### **19/0512/F - 87 Blackwall Lane, Greenwich, SE10 0AP – Non – material Amendments**

#### **1.0 Non-Material Amendments**

project number	drawing number	revision
4348	0334	P1

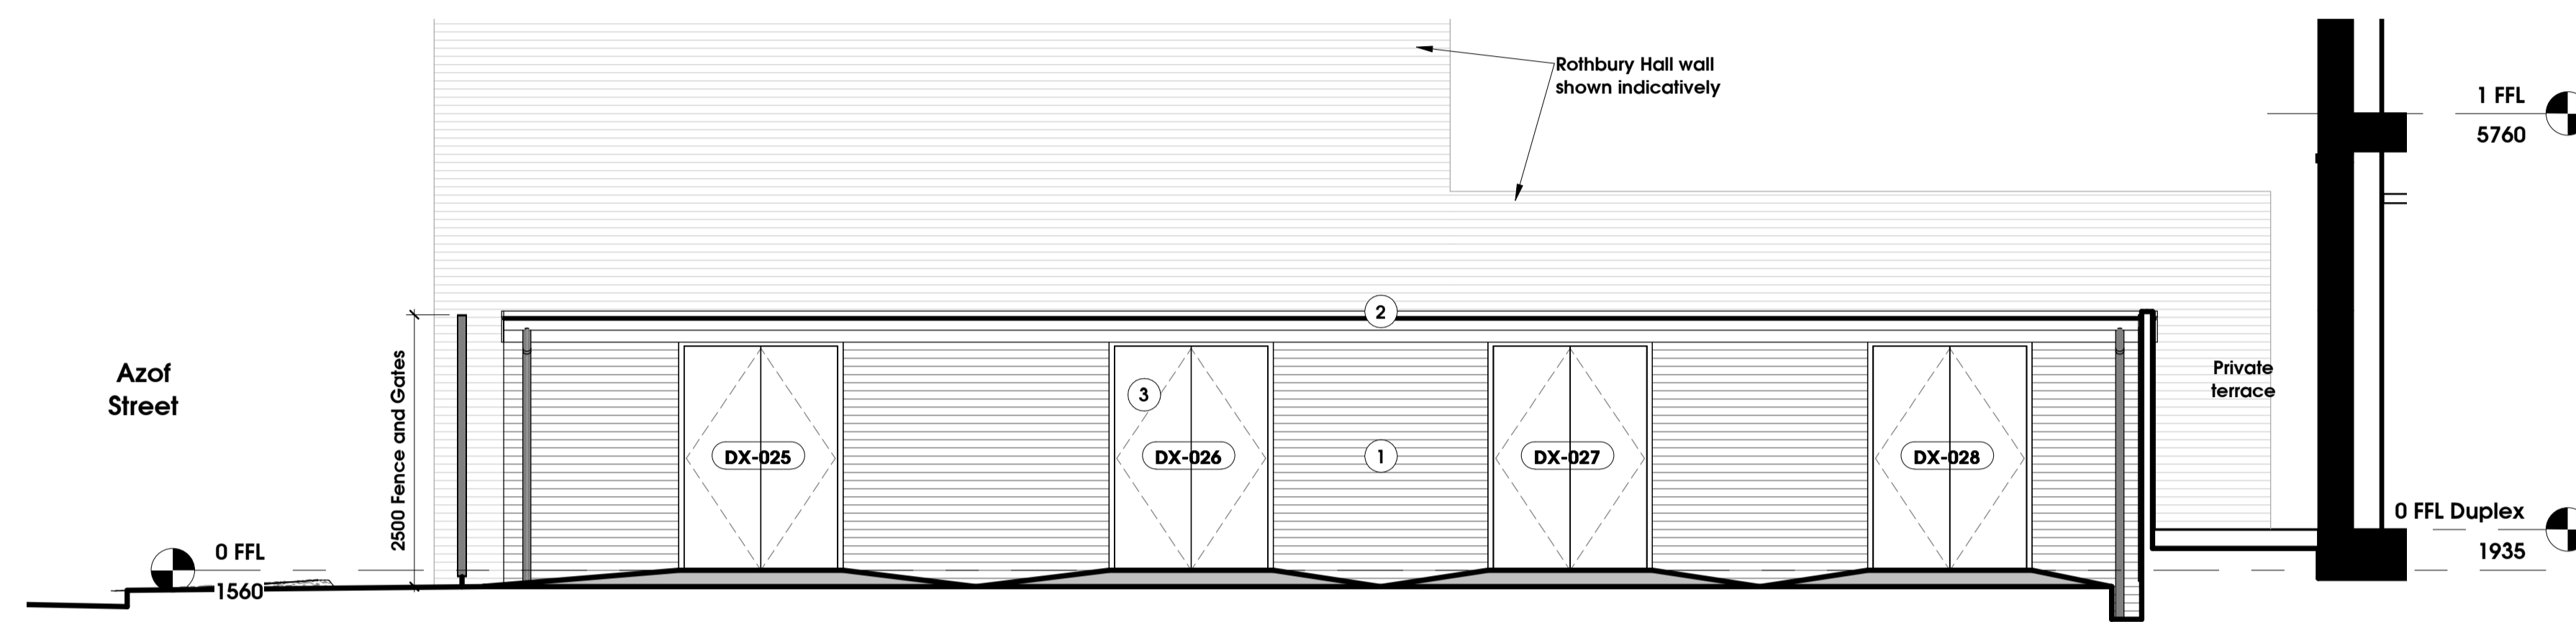
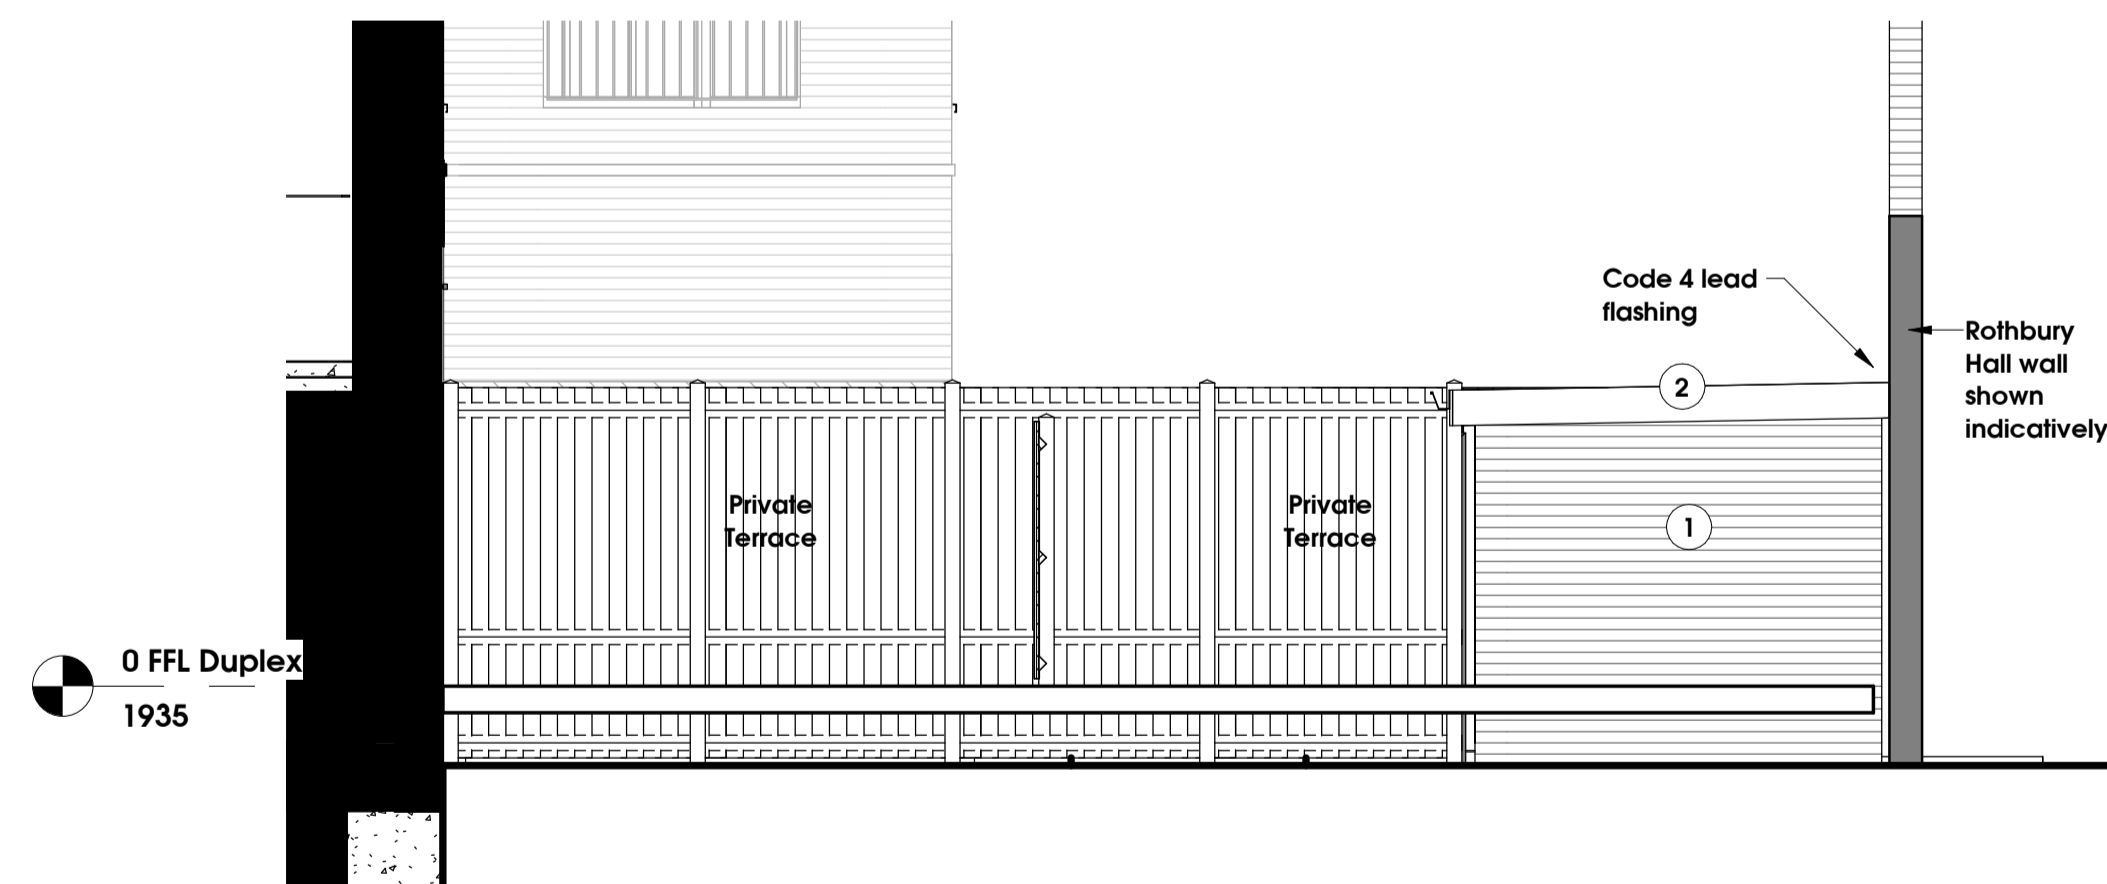
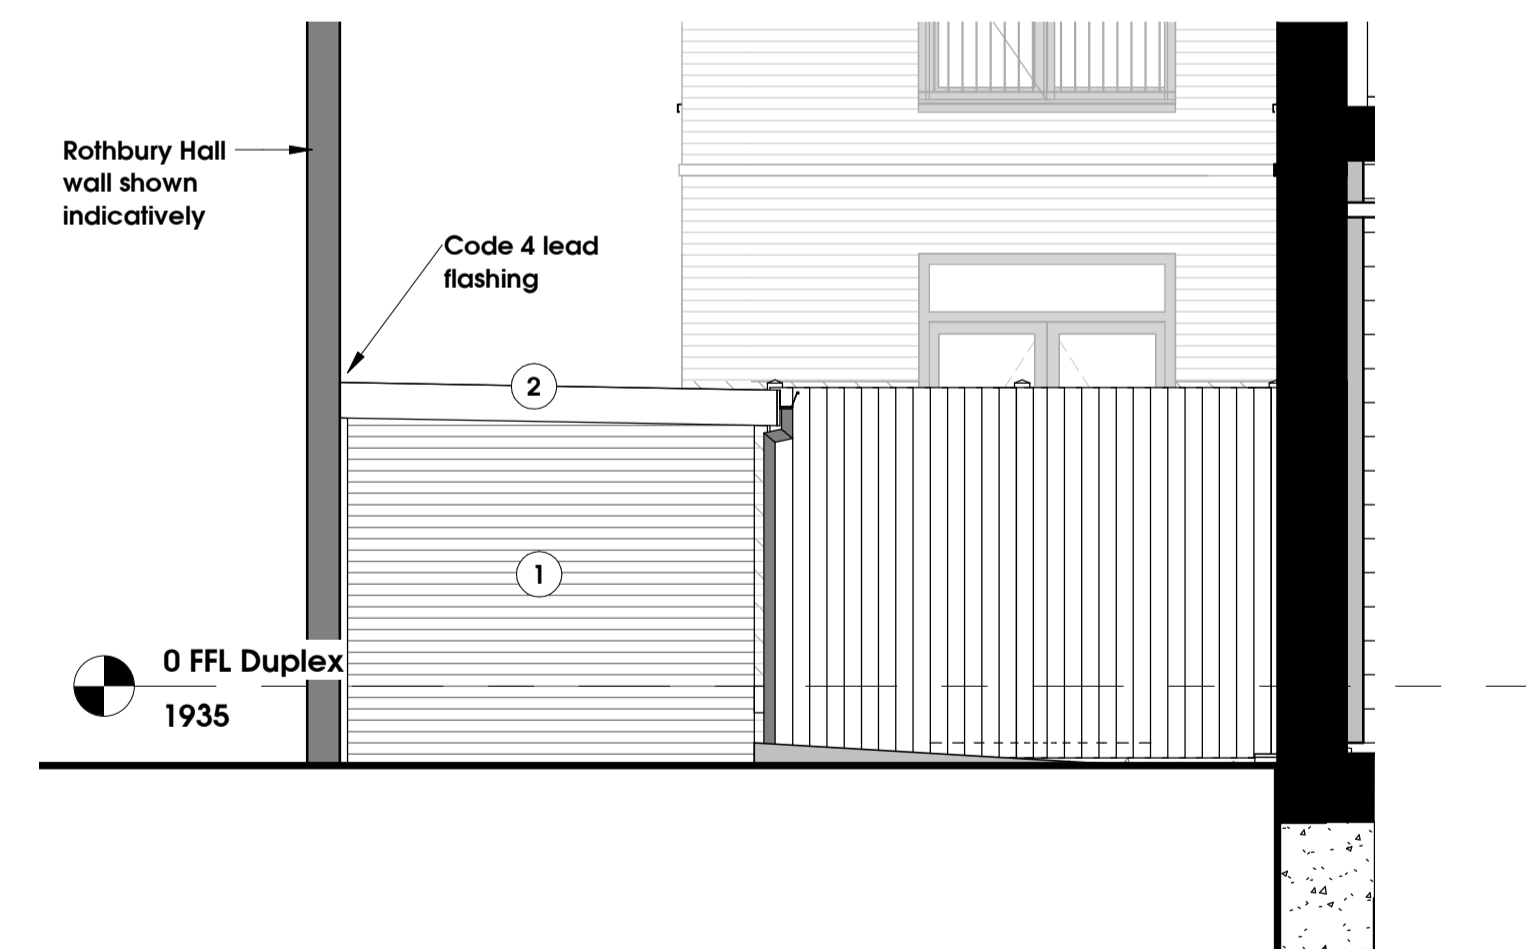
- 7.1 Following consultation with our Secure by Design Officer we have been asked to enclose the bike store with robust materials. The bike store walls will be constructed in similar materials to the rest of the building as shown in drawing 0334.
